# *City of Albuquerque*

Re: Site Plan submittal for building permit approval for T. Corlis, TC - Office Warehouse,  
----- Paseo Alameda NE., Alameda Business Park - Lots 7 & 8. [C-16 / D006A]  
Engineer's Stamp dated 2/13/2000.

Written Comments: File # C-16 / D006A  
3/02/2000

RE: DRAINAGE PLAN FOR TC OFFICE WAREHOUSE (C-16/D006A) SUBMITTED  
FOR BUILDING PERMIT APPROVAL

**C-1**

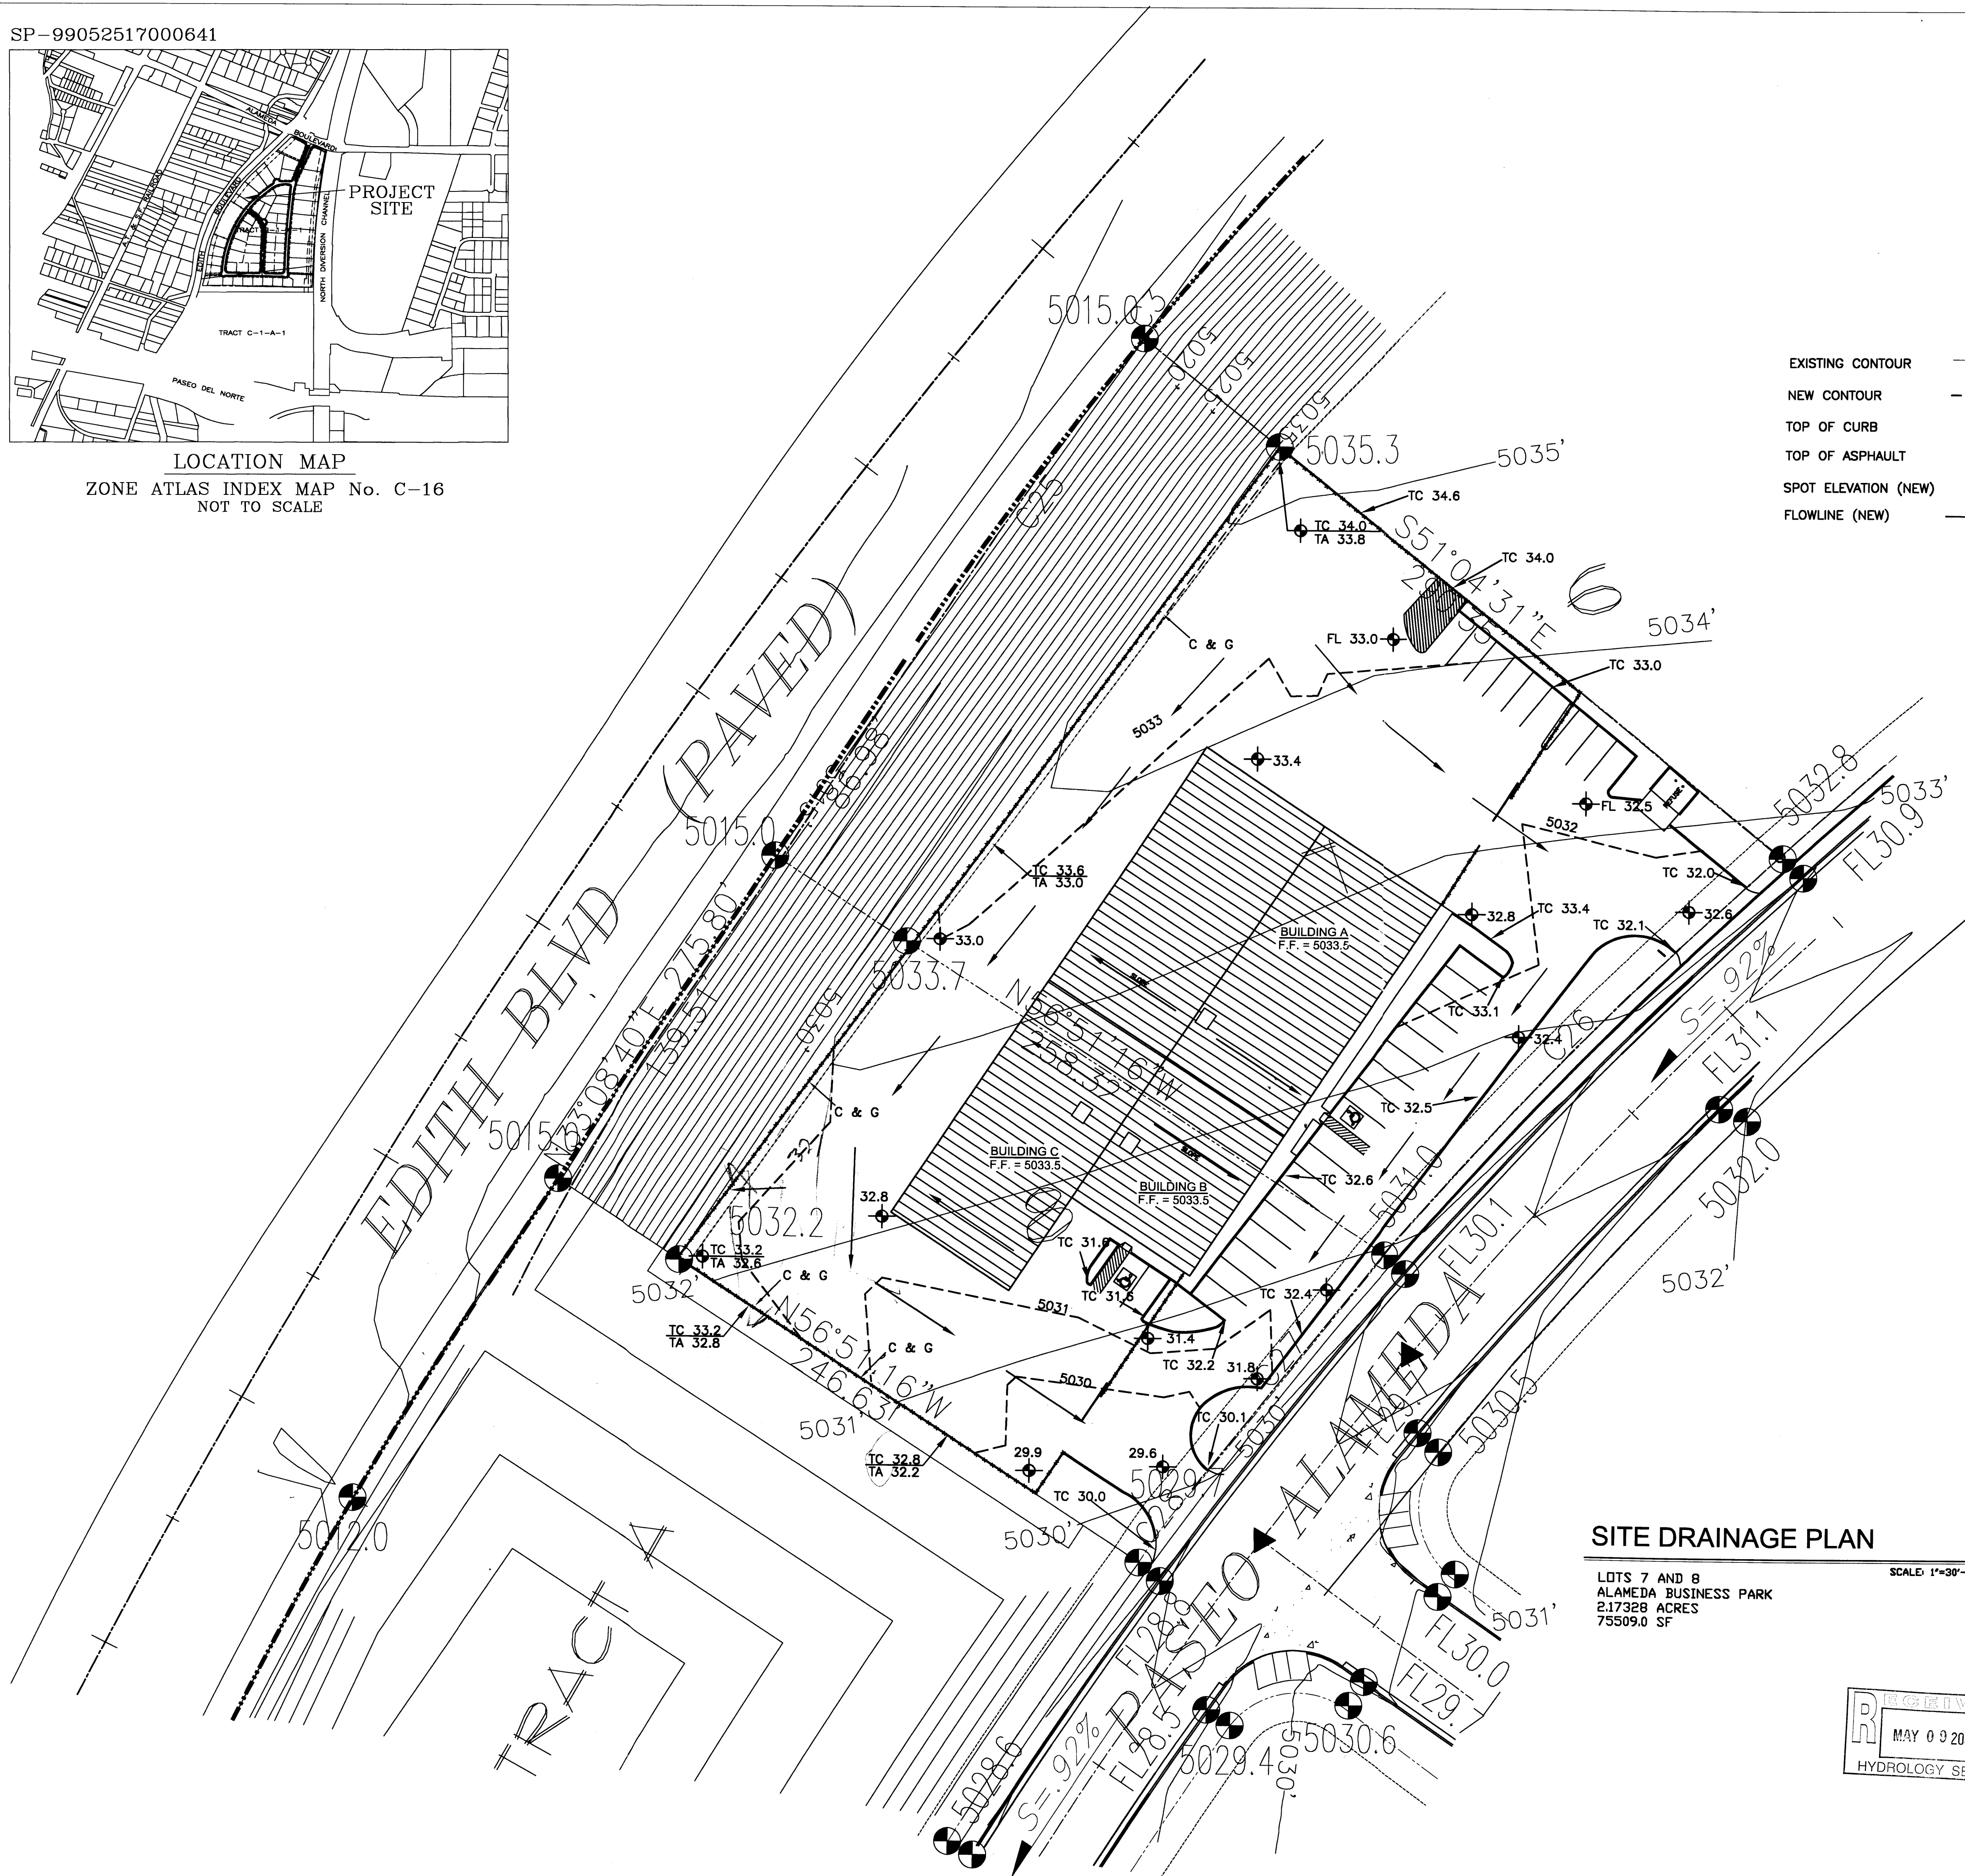
It is not clear whether the contours shown are existing or proposed, but both should be shown; the same can be said of the spot elevations. In several cases, there are spot elevations, e.g., 33.0, which is located on the wrong side of the 34 foot contour line, that lead to confusion. Please check your grading.

You will need a legend on your plan, and grades for top of curb and gutter in critical locations to show how the site drains.
